DEPARTMENT OF PUBLIC WORKS

RE: Hyak PUD Addendum

Public Works has reviewed the additional materials provided by the applicant (Hyak PUD) and our comments appear below for your consideration.

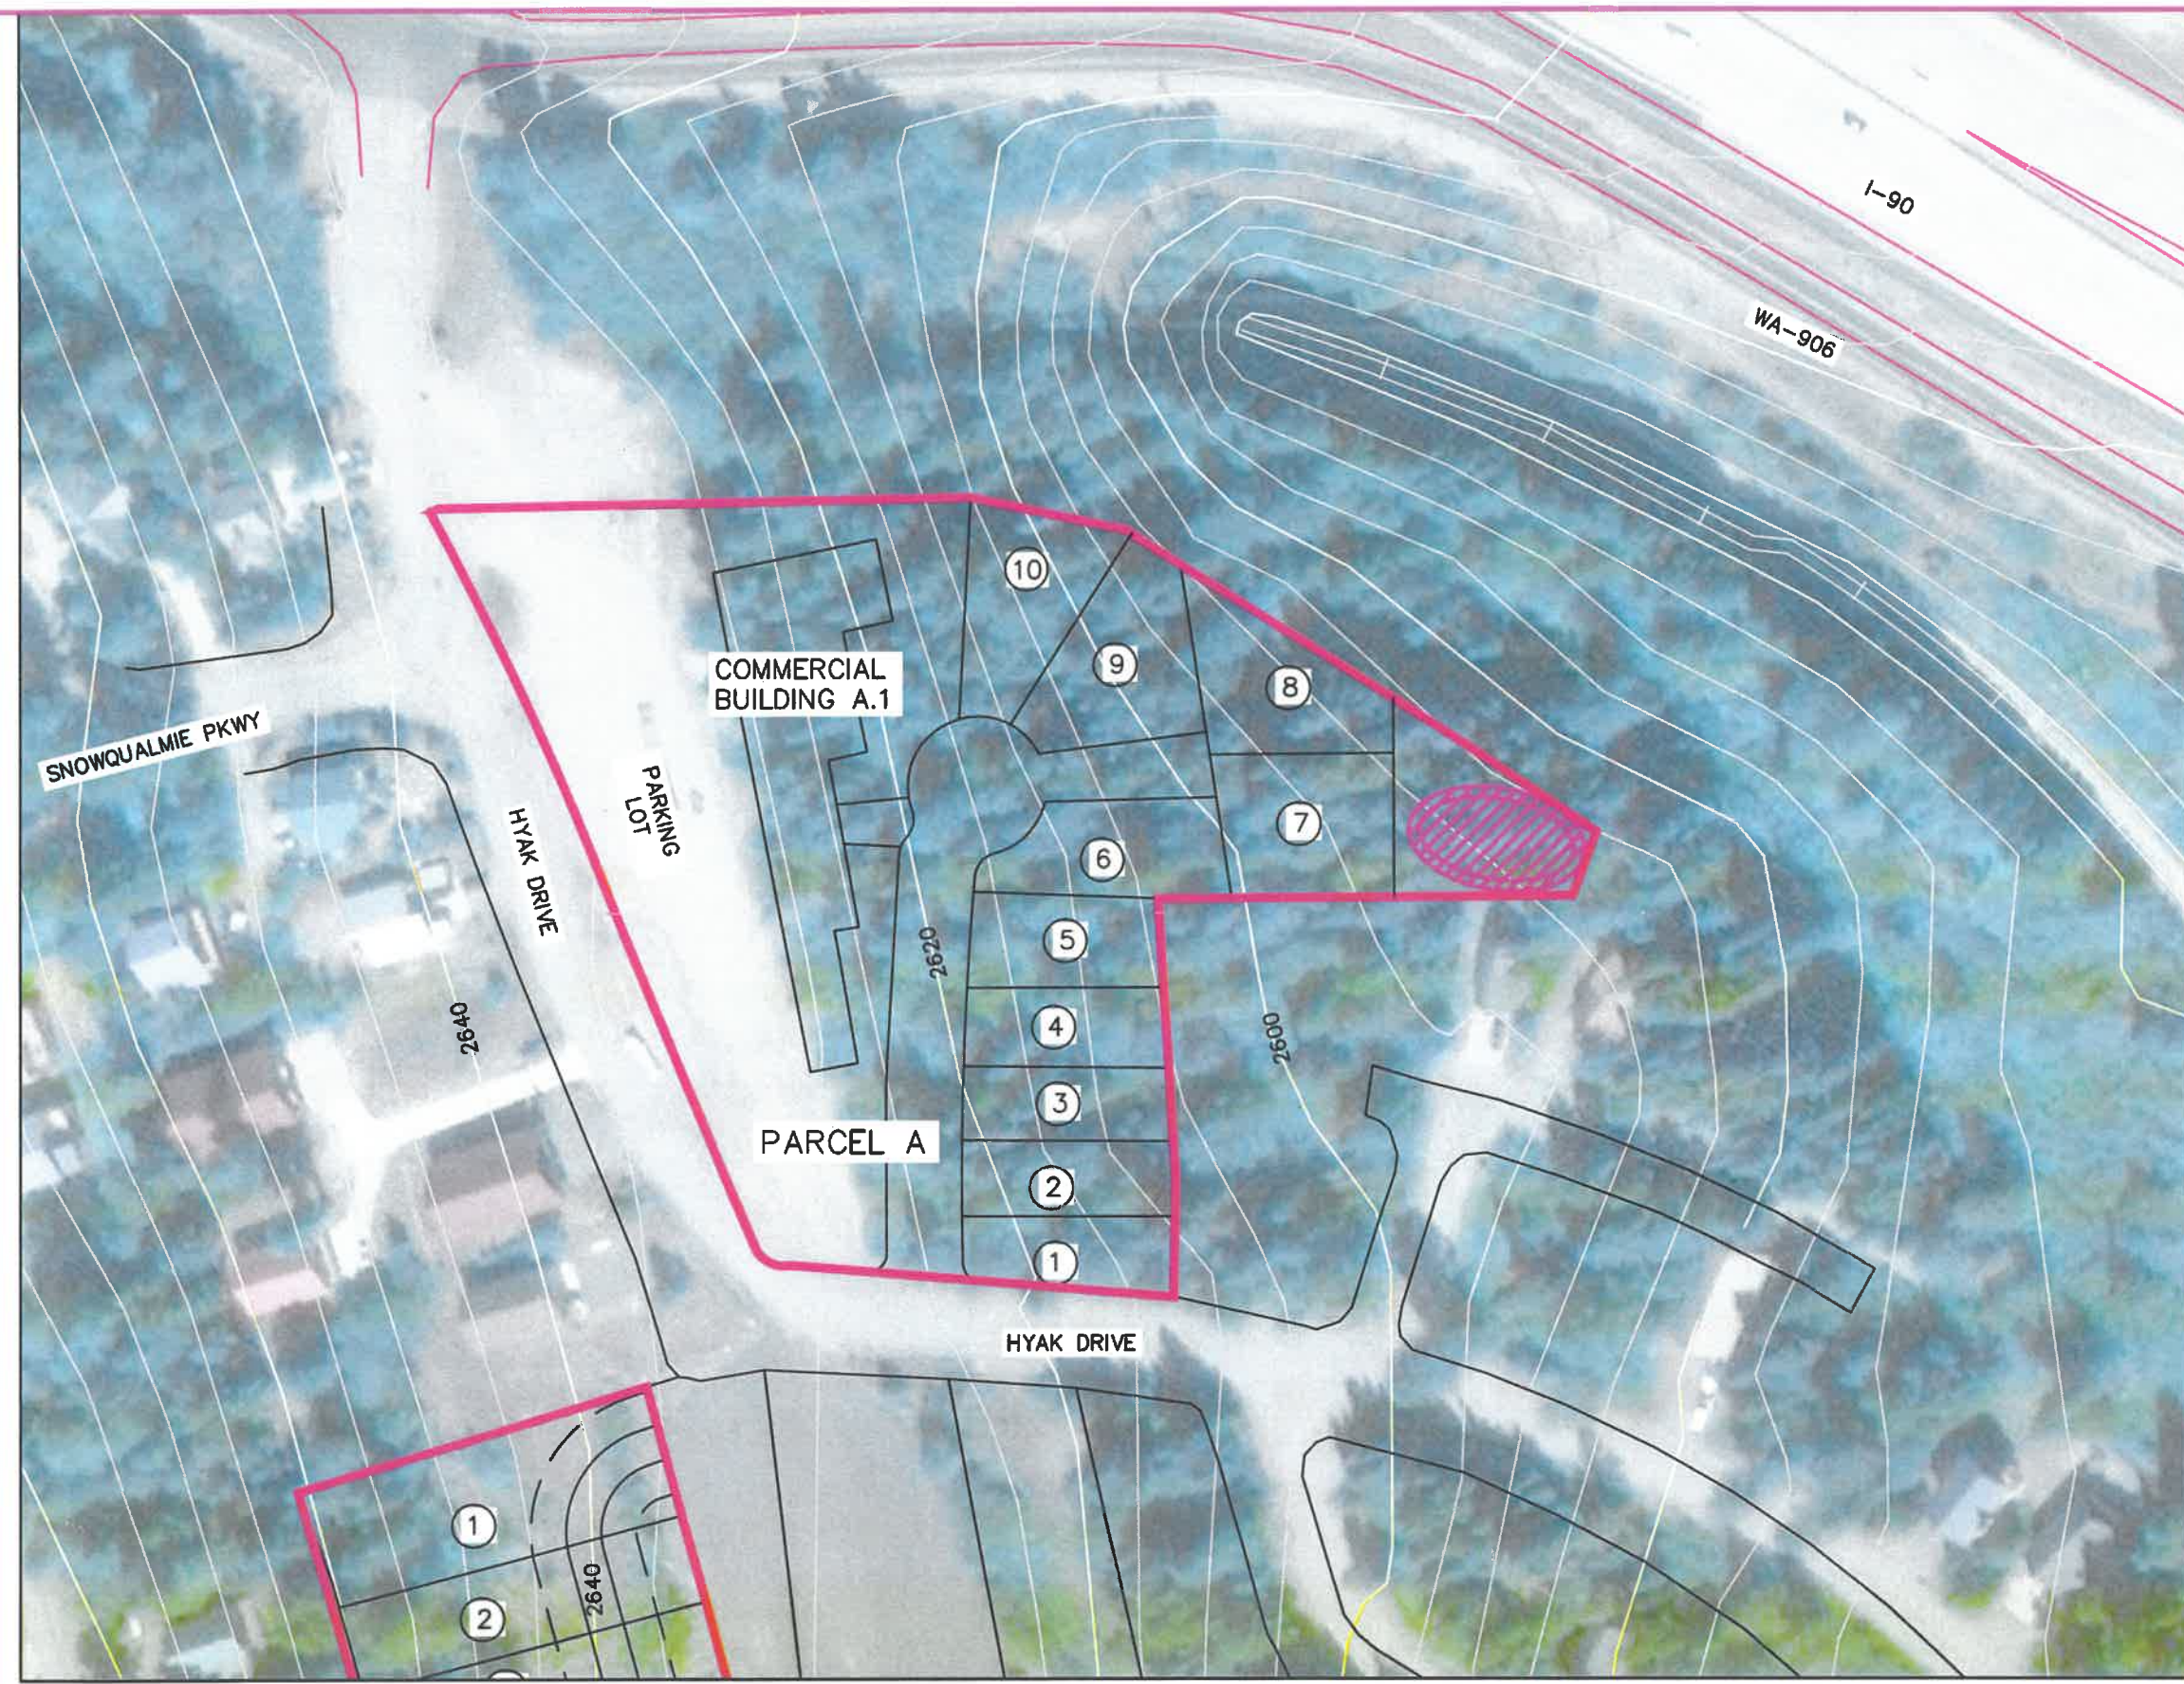
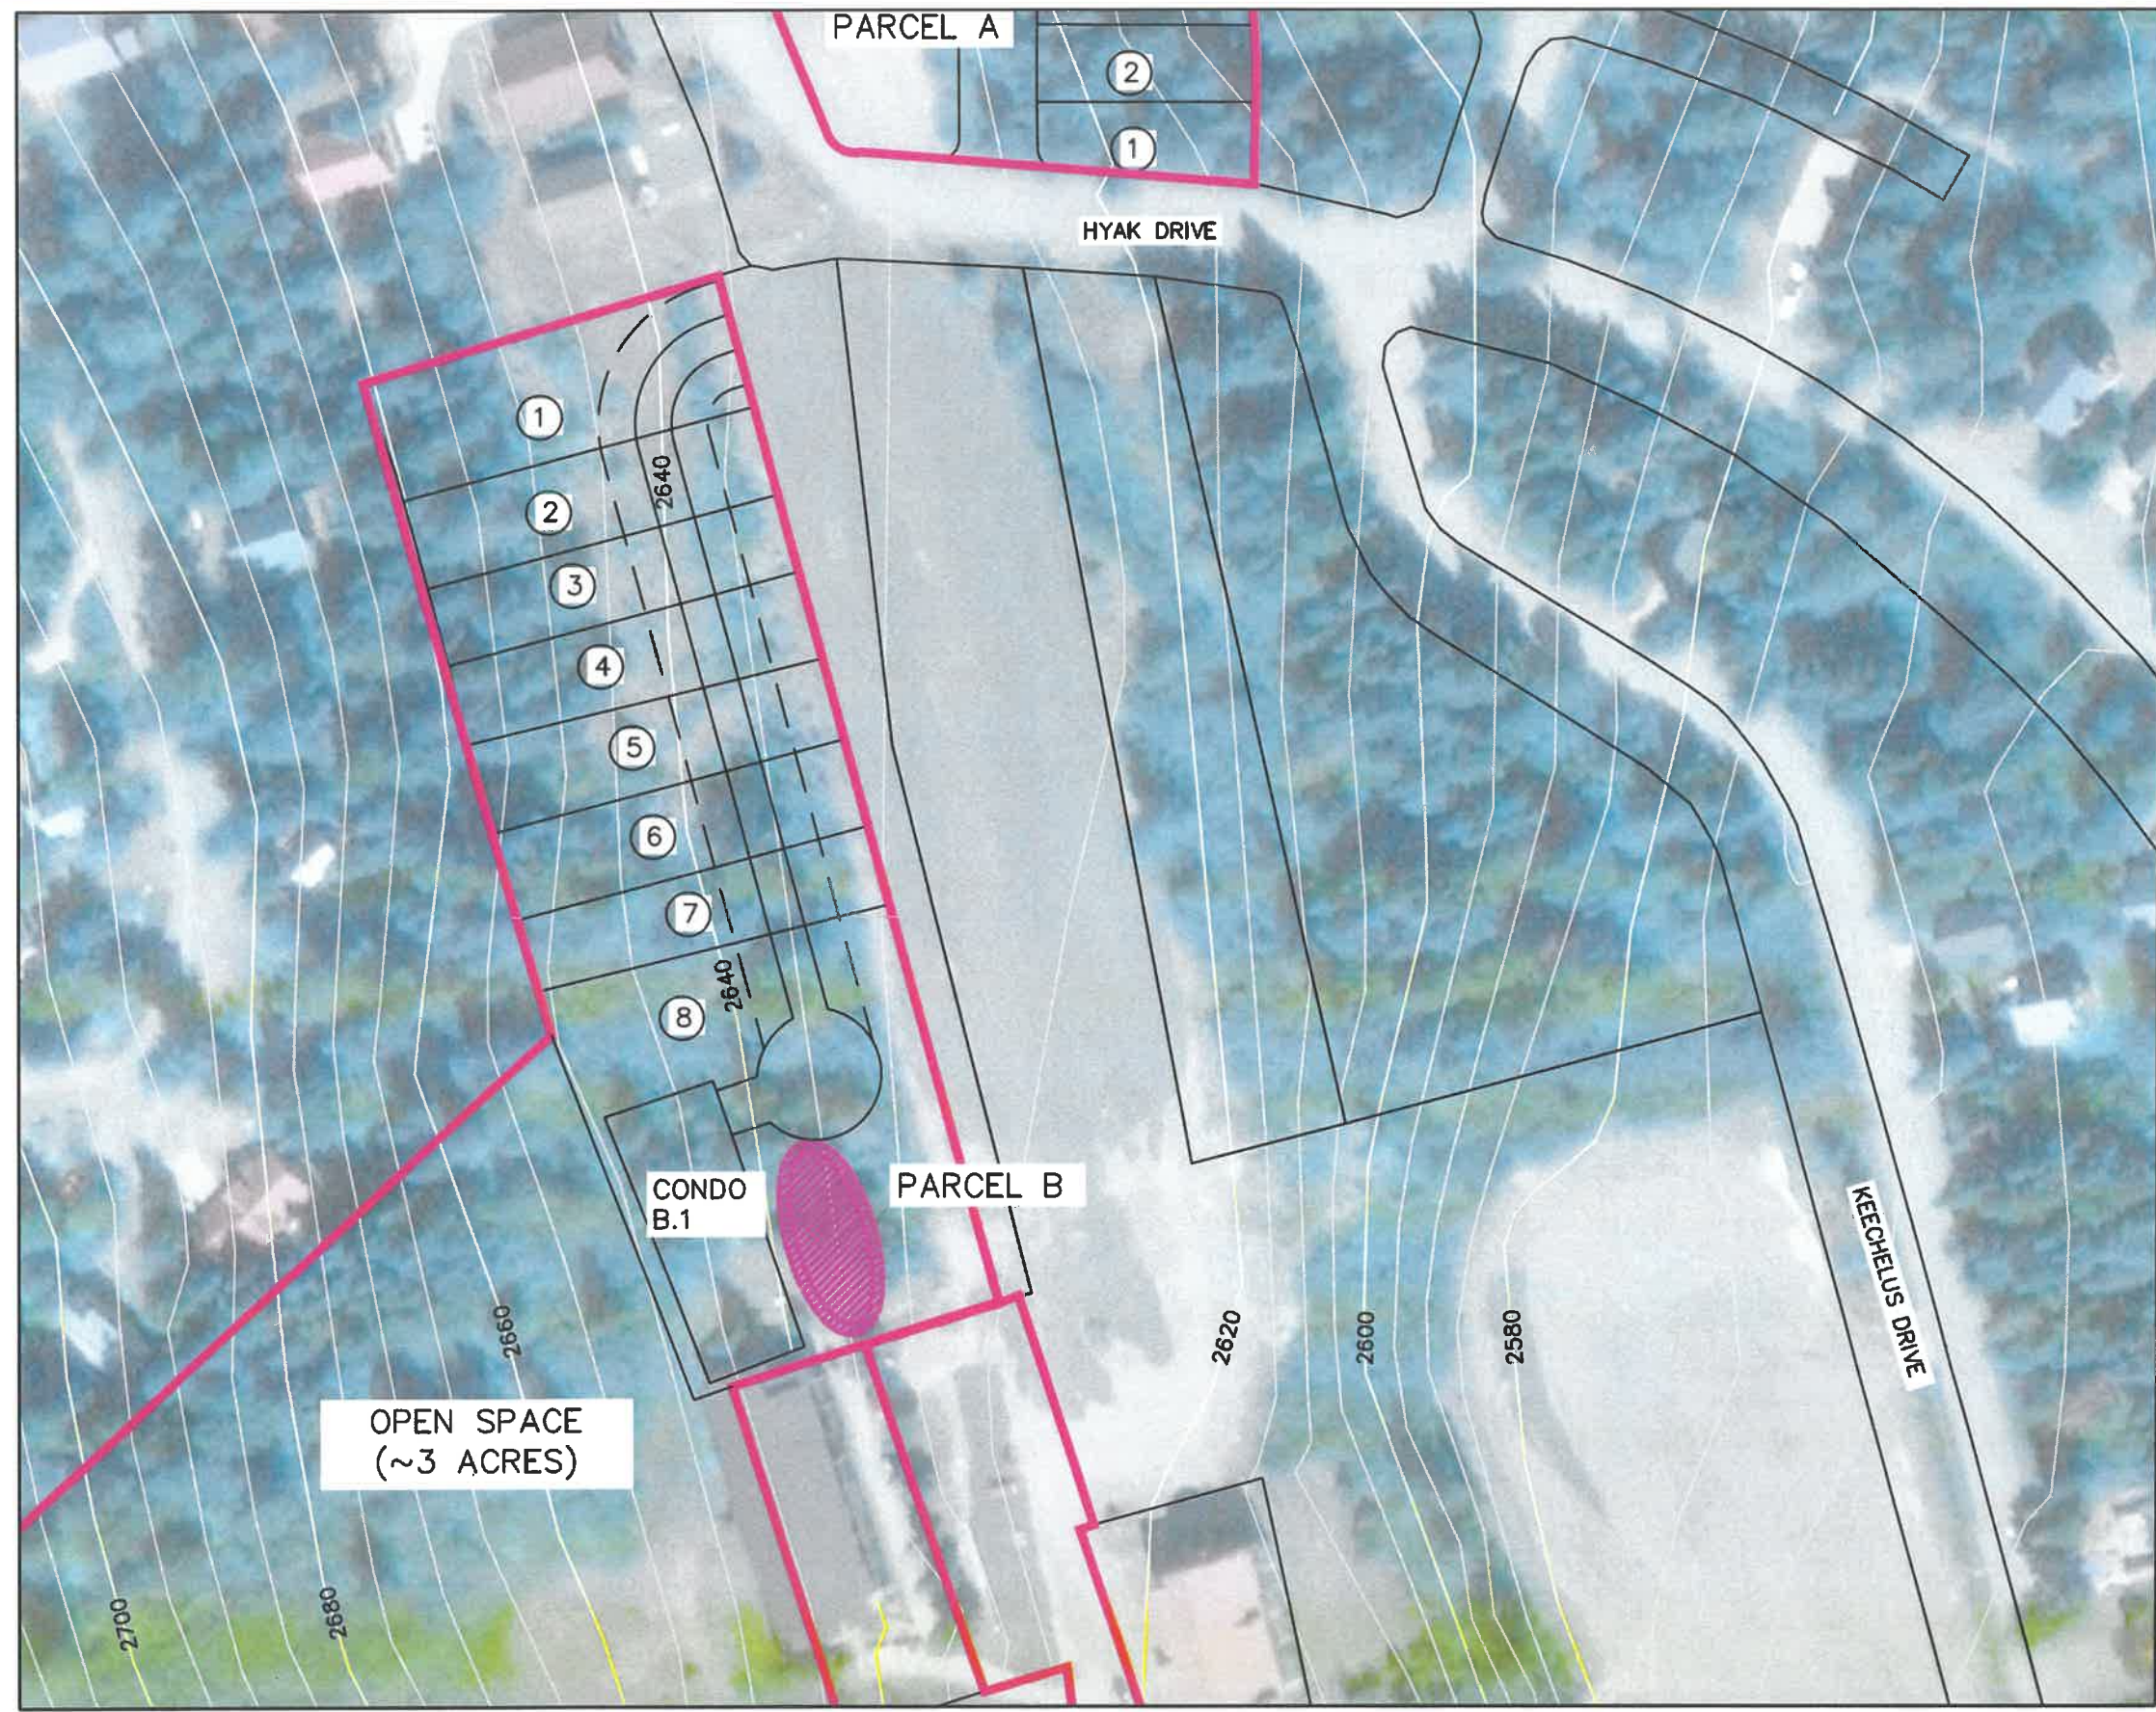
1. Several of the proposed stormwater ponds appear to span multiple contour intervals. The contour interval appears to be five feet. Please be advised that constructing the proposed ponds will likely impact developable land in the vicinity of the ponds. Public Works will assess the viability of pond construction on hill side slope at the time of civil engineering design submittal.
